Development Control  
Burnley Borough Council

Your ref 2024/0249  
Our ref D3/2024/0249  
Date 23<sup>rd</sup> April 2024

**Application no:** 2024/0249

**Address:** Fencegate Farm Ribchester Road Langho BB6 8AL

Proposed Site Plan 1 : 500 @ A3

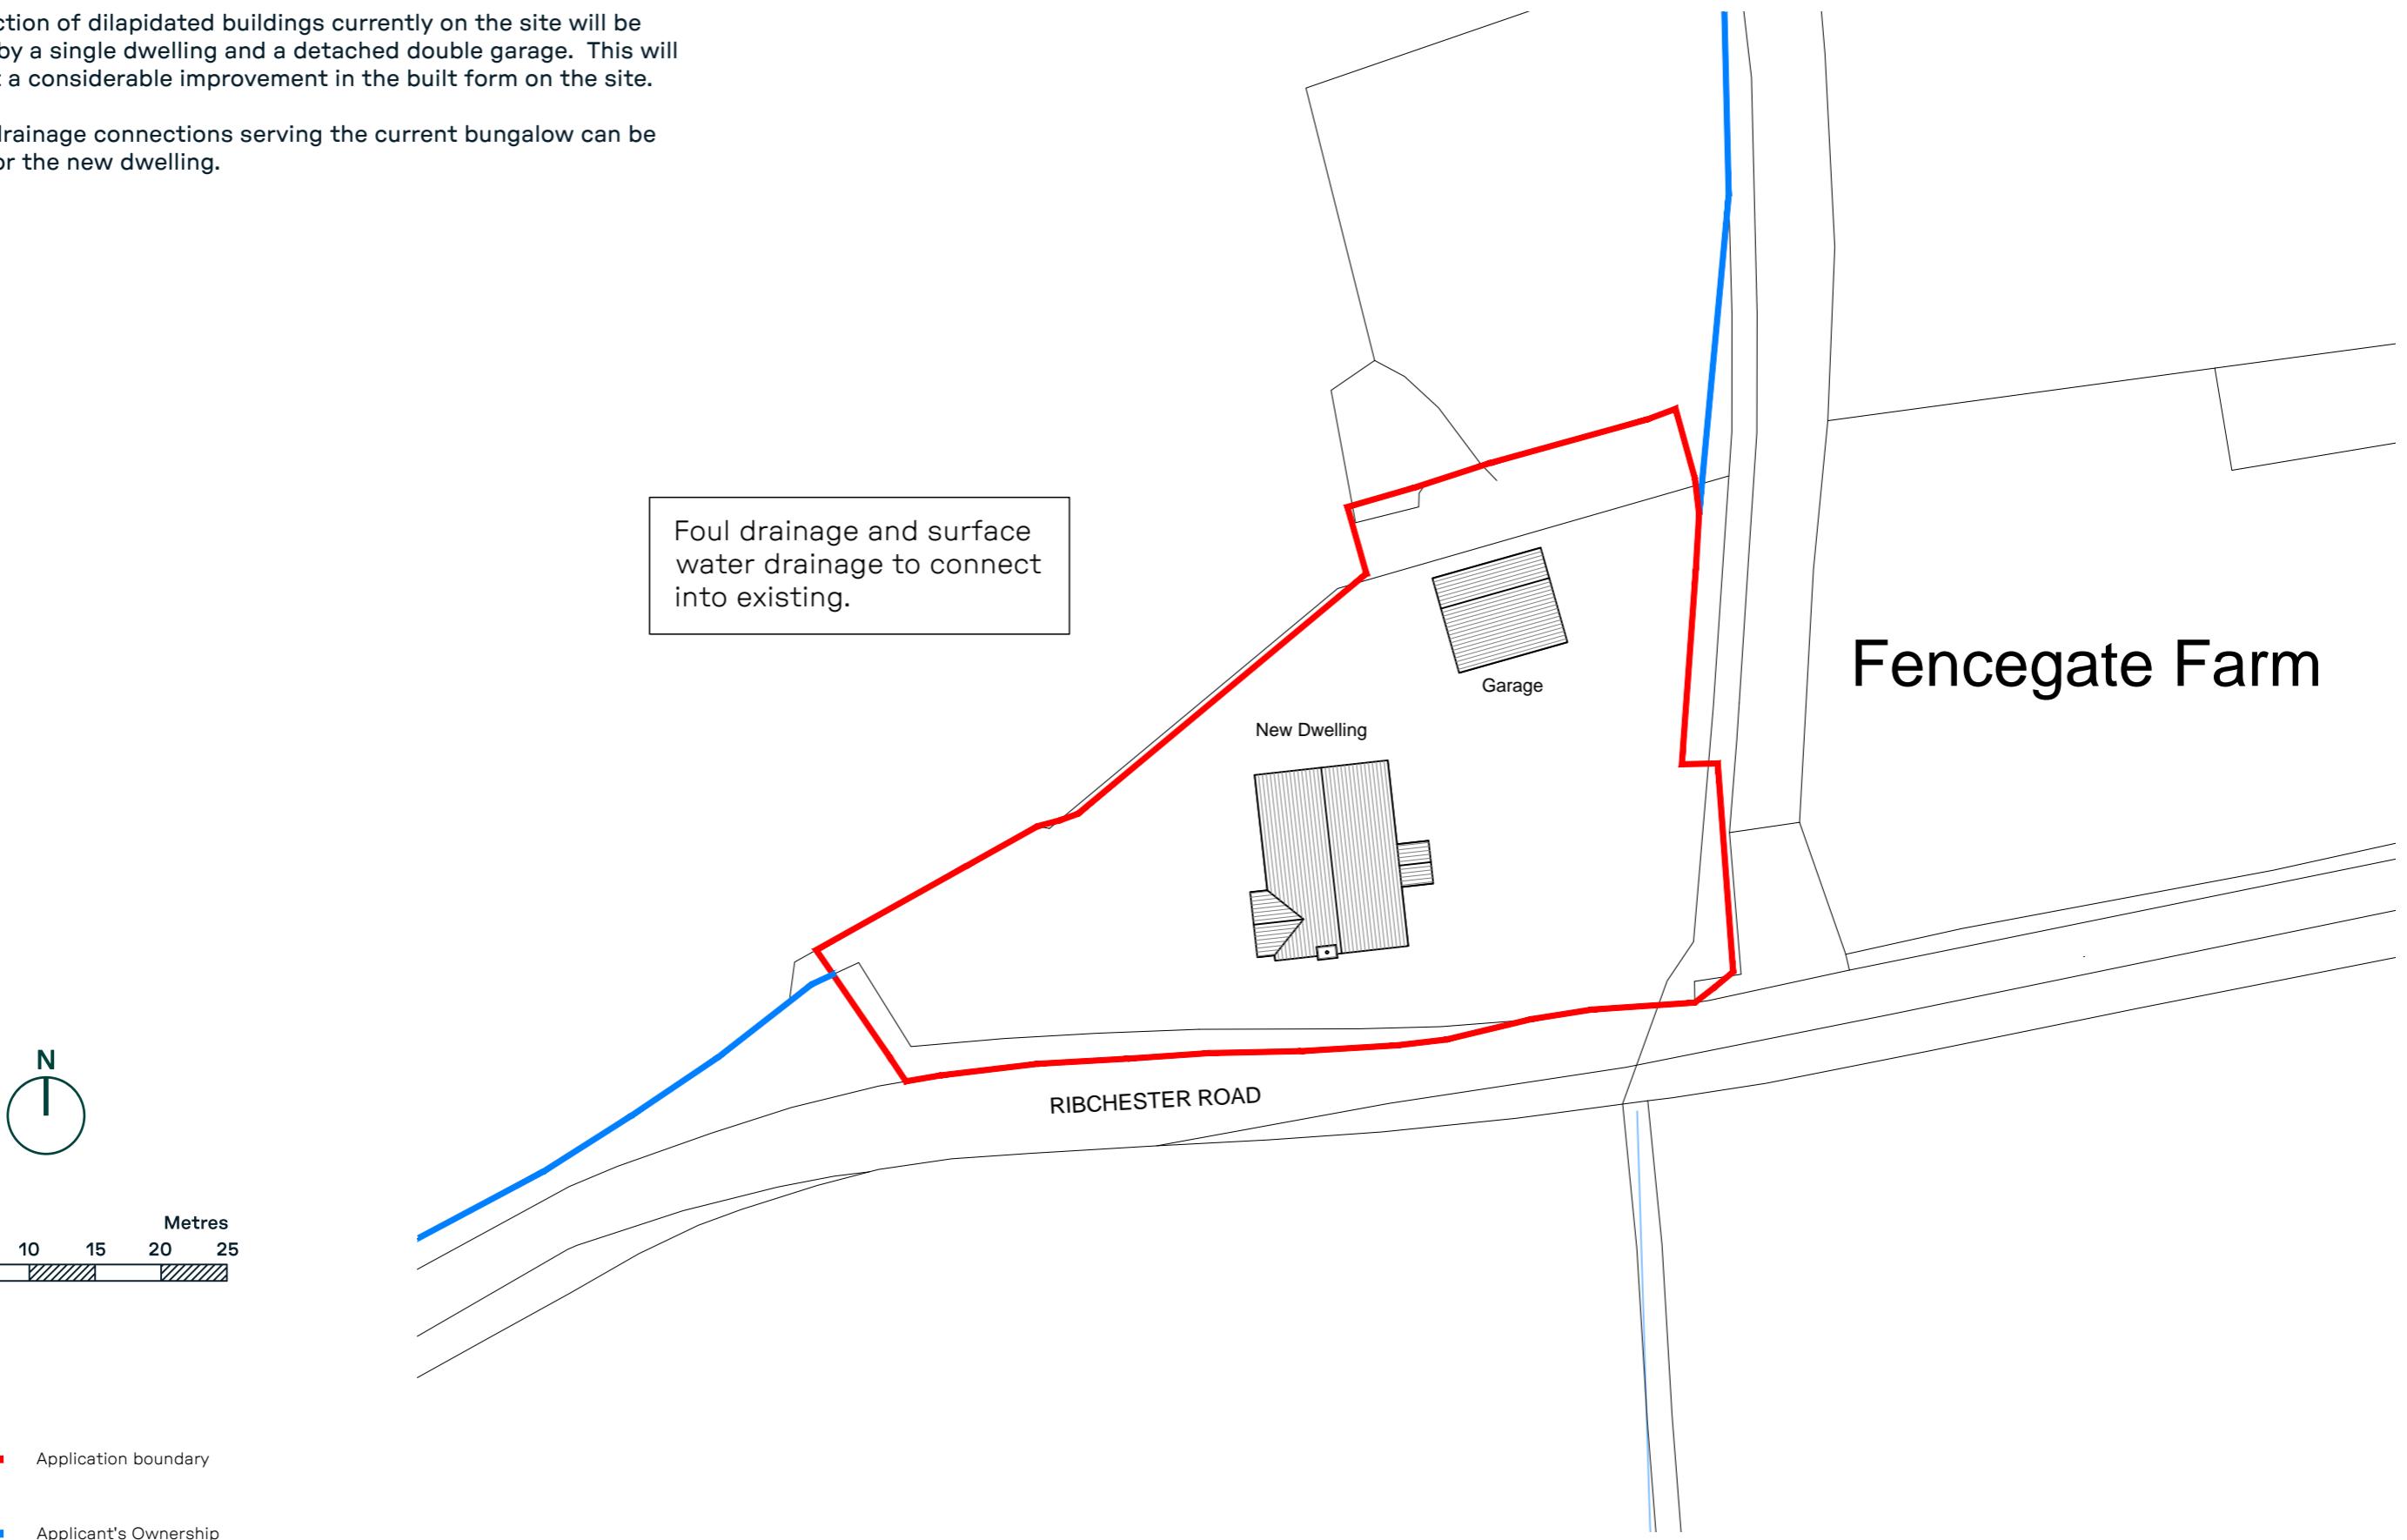
Due to the extensive nature of the application, it is expected that a charging point for electric vehicles shall be included with-in the development to promote sustainable modes of transport. This shall be fitted in line with the DfT guidance regarding Electric Vehicle Charging in Residential and Non-residential buildings, which states: - charge points must have a minimum power rating output of 7kW, be fitted with a universal socket that can charge all types of electric vehicle.

Before the access is used for vehicular purposes, that part of the access extending from the highway boundary for a minimum distance of 5m into the site shall be appropriately paved in tarmacadam, concrete, block paviours, or other hard material to be approved by the Local Planning Authority.

The surface water from the approved driveway/hardstanding/car park should be collected within the site and drained to a suitable internal outfall. Prior to commencement of the development details of the drainage strategy shall be submitted to and approved in writing by the Local Planning Authority. The scheme shall be implemented in accordance with the approved details.

No building or use hereby permitted shall be occupied or the use commenced until the car parking area has been surfaced or paved in accordance with a scheme to be approved by the Local Planning Authority and the car parking spaces and manoeuvring areas marked out in accordance with the approved plan. The car parking area shall thereafter be kept free of obstruction and available for the parking cars at all times.
